Planning Application, Ribble Valley District
3/12/0824 Ground floor office, 6 Abbey Works, Back King Street, Whalley

I am recommending refusal of this application on highway safety grounds.

EXISTING AND PROPOSED LAYOUT

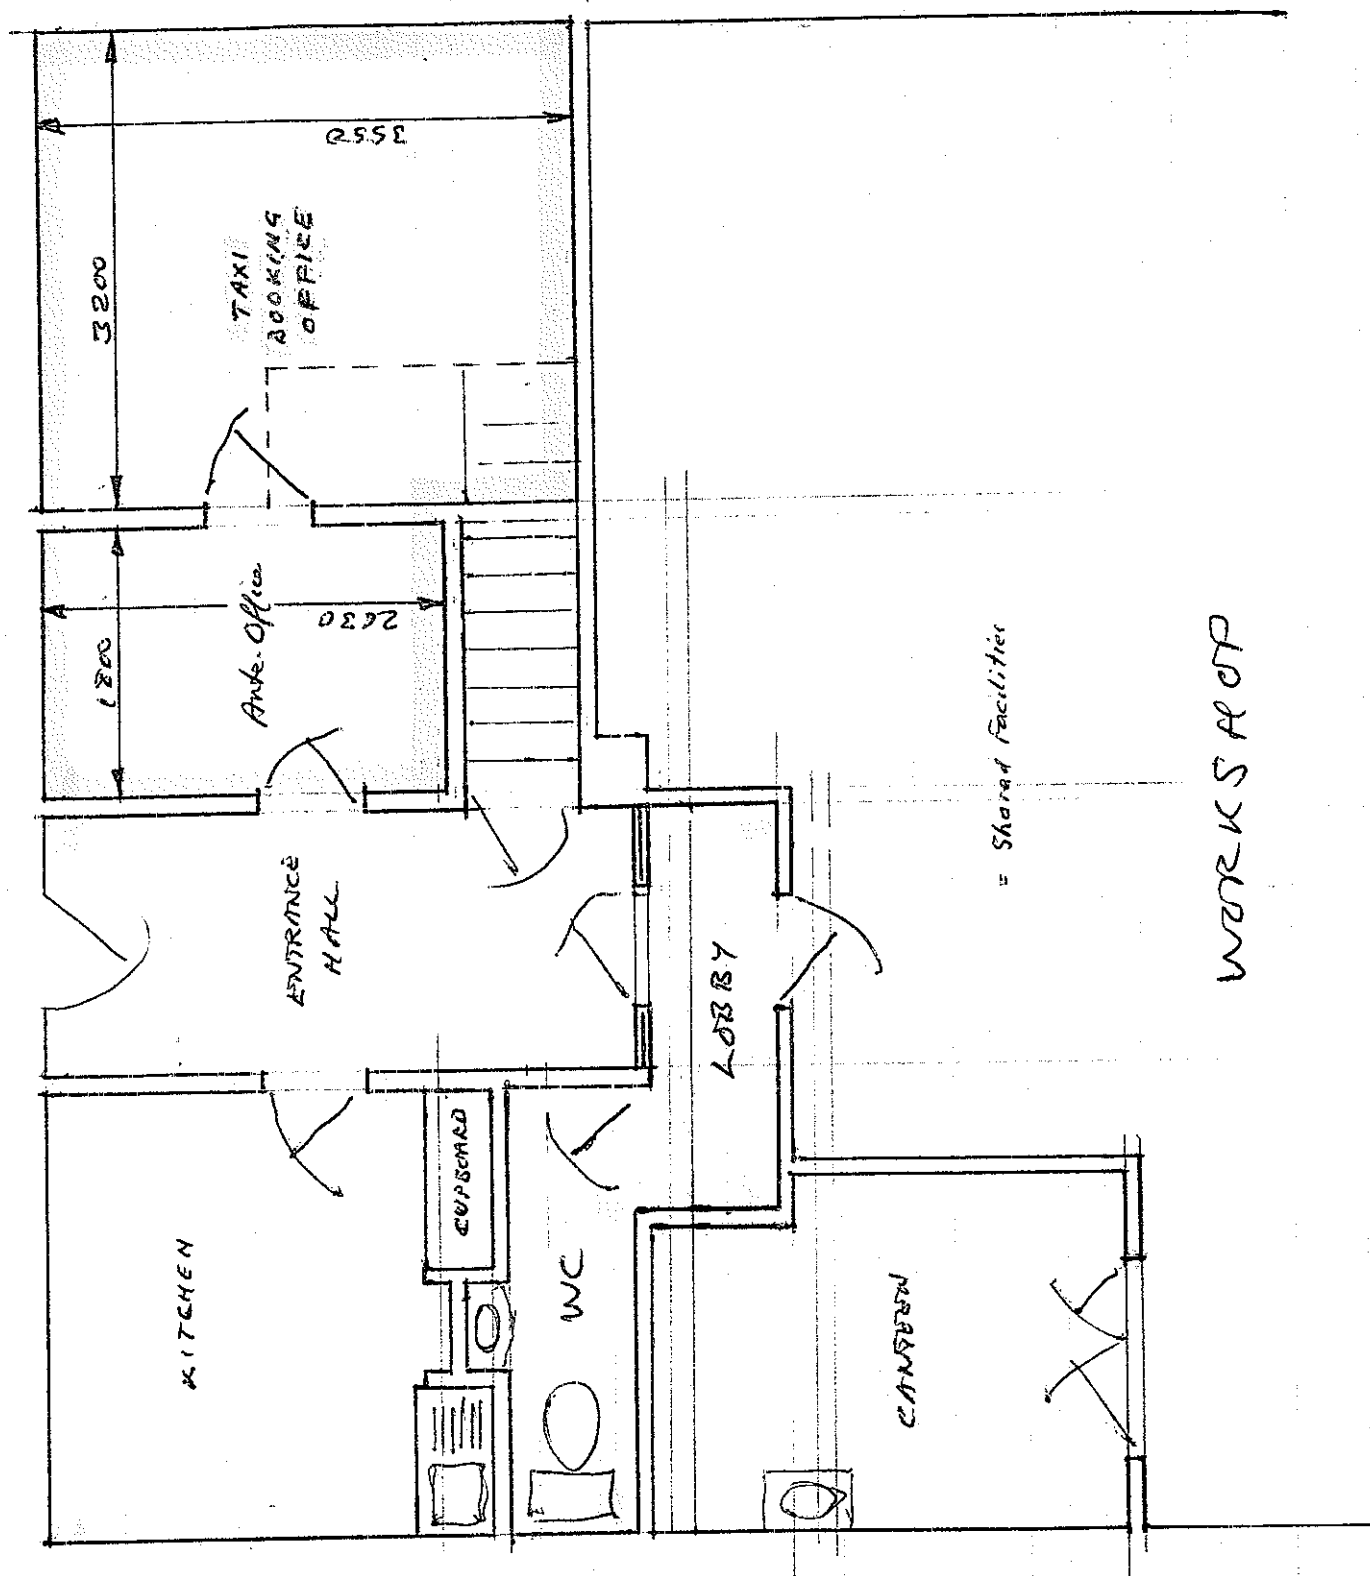
The proposed development of this site will introduce pedestrians into an area where there are no footways and vehicles manoeuvring to a number of locations within a relatively confined area.

There are two additional parking spaces identified in the vicinity of the existing office. However, as with the existing spaces, these are poorly define and do not help to secure a safe area in the immediate vicinity for visitors to the office.

I am recommending refusal of this application on highway safety grounds as I am satisfied that the previous highway safety justifications for prohibiting pedestrian access to the site remain relevant and that providing access for pedestrians to the taxi booking office would be detrimental to highway safety.
